**KIRKLEES METROPOLITAN COUNCIL
DEVELOPMENT & MASTER PLANNING SERVICE**

**DELEGATED DECISION FOR PRIOR APPROVAL FOR CHANGE OF USE
FROM COMMERCIAL, BUSINESS AND SERVICE USES TO
DWELLINGHOUSES**

Reference no. 2023/CL/92103/E

Site Address	Dixon Hall And Co Ltd, Grafton Street, Batley, WF17 6AR
---------------------	--

3 Proposed Site Plan
1:200

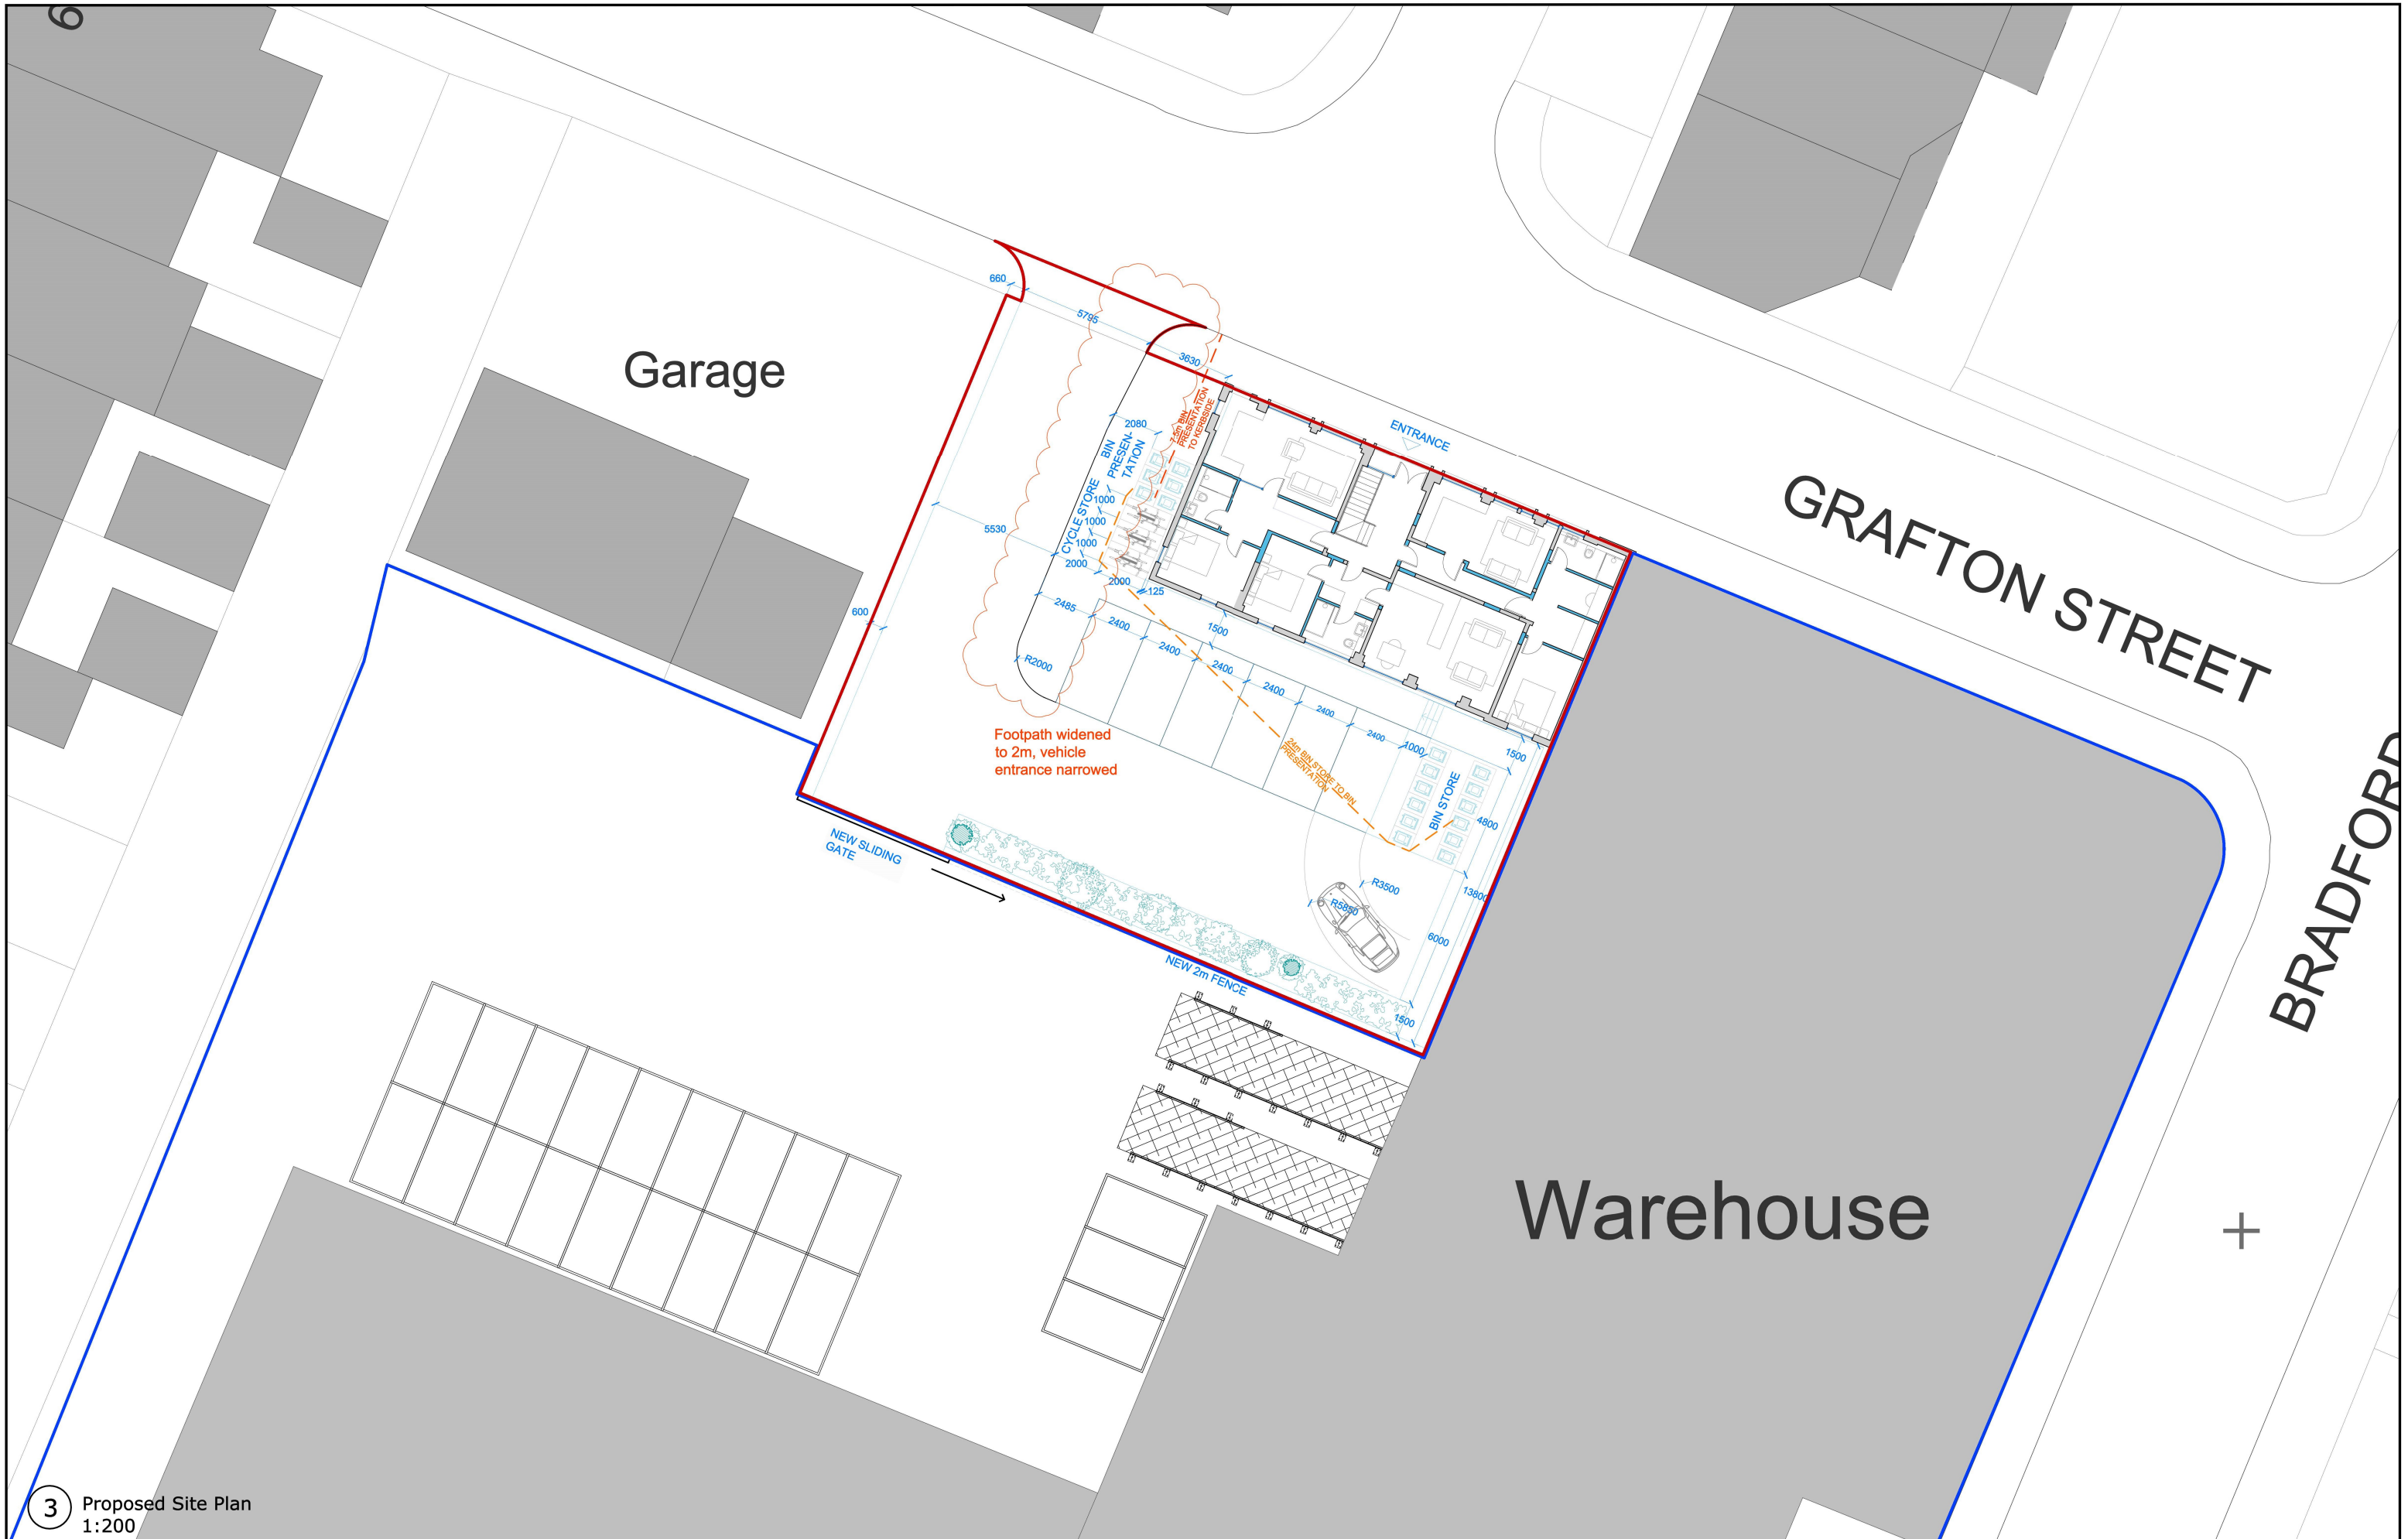
To the rear of the building is an outdoor lot which is associated with the site. On the south bank of the lot is an entranceway to the adjacent site. The applicant has provided information regarding pedestrian and vehicular access to the site, parking and bin storage. Six on-site parking spaces have been marked to rear of the site. There is adequate bin storage and cycle storage provided within the site.

Submitted plans are insufficient for KC Highways Development Management to support the application. Swept paths do not show the largest vehicle likely to enter, exit and turn within the site considering the adjacent 'Dixon Hall Tools' site. There would be obstructed visibility for vehicle exiting the proposed parking area and vehicles exiting the access to the remainder of 'Dixon Hall Tools' site.
